OXFORDSHIRE COUNTY COUNCIL'S RESPONSE TO CONSULTATION ON THE FOLLOWING DEVELOPMENT PROPOSAL

Application no: 21/04275/OUT

Proposal: OUTLINE - with all matters reserved except for Access - Mixed Use Development of up to 3,100 dwellings (including extra care); residential and care accommodation(C2); mixed use local centre (comprising commercial, business and service uses, residential uses, C2 uses, local community uses (F2(a) and F2(b)), hot food takeaways, public house, wine bar); employment area (B2, B8, E(g)); learning and non-residential institutions (Class F1) including primary school (plus land to allow extension of existing Gagle Brook primary school); green Infrastructure including formal (including playing fields) and informal open space, allotments, landscape, biodiversity and amenity space; burial ground; play space (including Neaps/Leaps/MUGA); changing facilities; ground mounted photovoltaic arrays; sustainable drainage systems; movement network comprising new highway, cycle and pedestrian routes and access from highway network; car parking; infrastructure (including utilities); engineering works (including ground modelling); demolition

Lead Local Flood Authority

Appendix A – Illustrative Surface Water Drainage Plan (10663-DR-01 D)

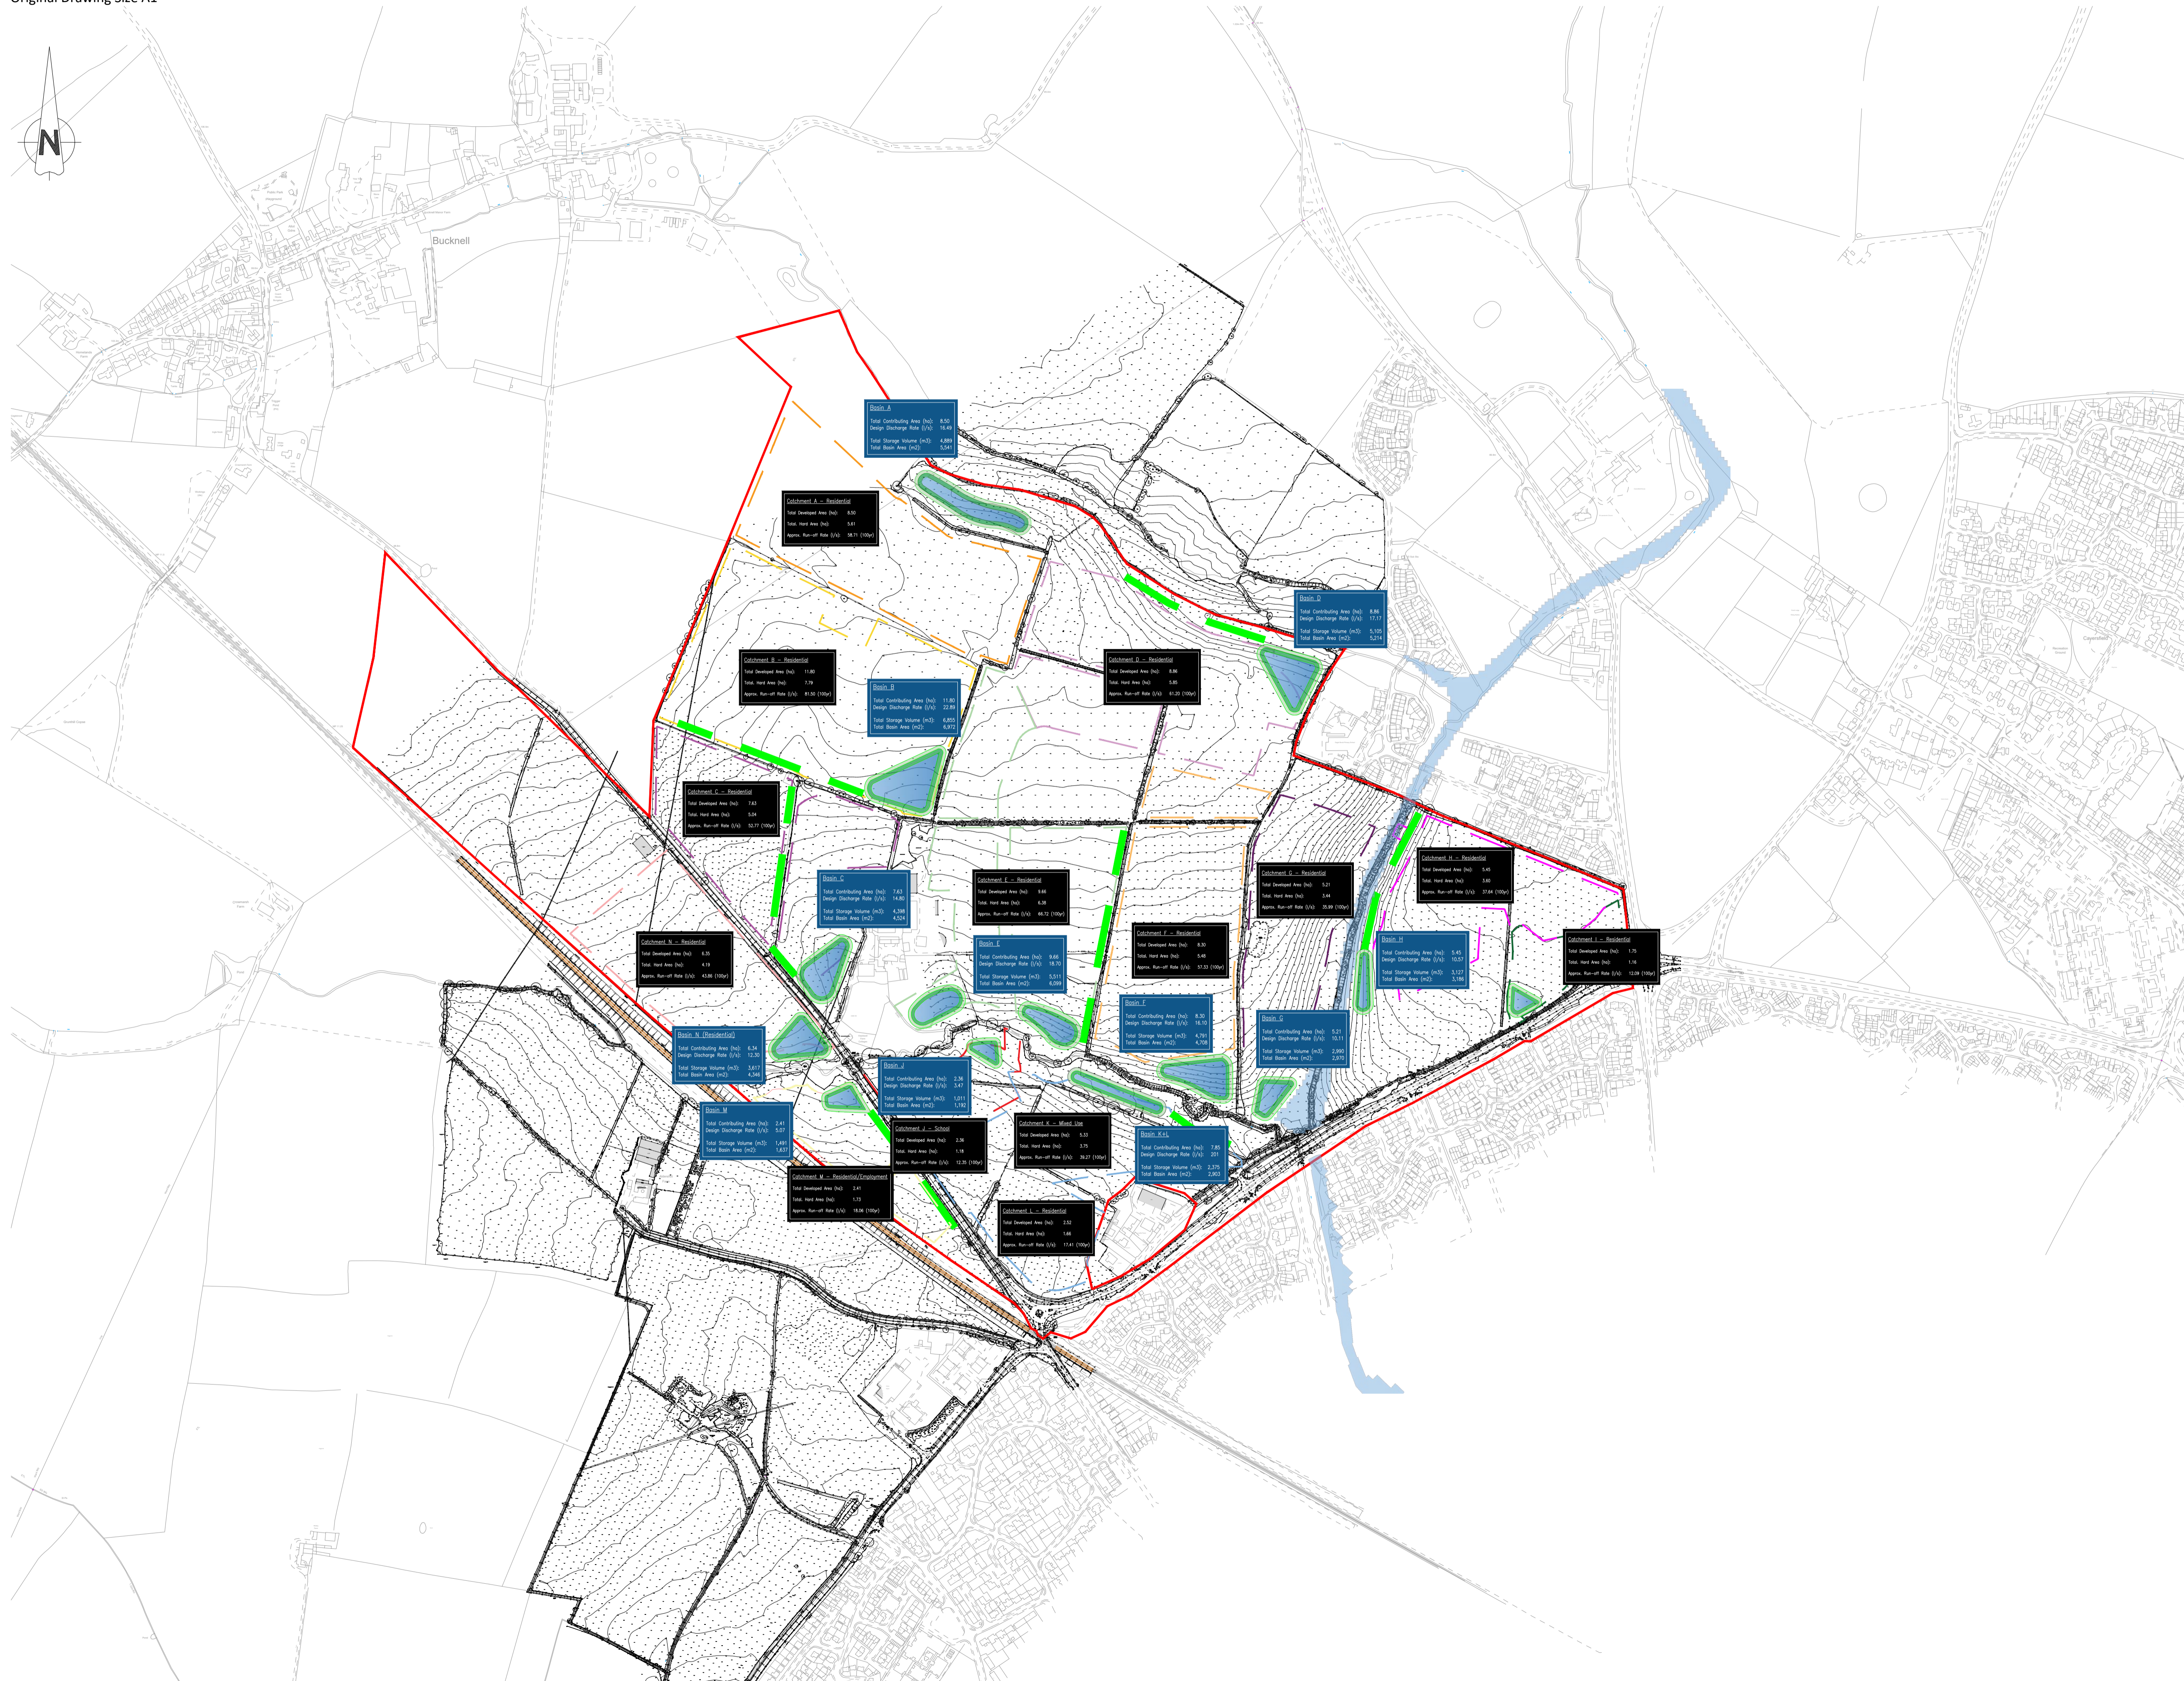
Identify infiltration basins and attenuation basins clearly on the drainage drawing. Include arrows to indicate the outfall location to the watercourse with the discharge rate. For the infiltration basins provide the discharge rate used in m/s.

Windes calculations and modelling of the proposed SuDS features to confirm capacity for the 1:100 year storm event plus 40% CC. Calculations only provided for catchments A to F. Provide calculations for all catchments.

The ground investigation report shows the majority of the site to be suitable for infiltration, however the use of infiltration basins is not maximised. There are some

attenuation basins that could be infiltration basins according to the infiltration testing report provided.
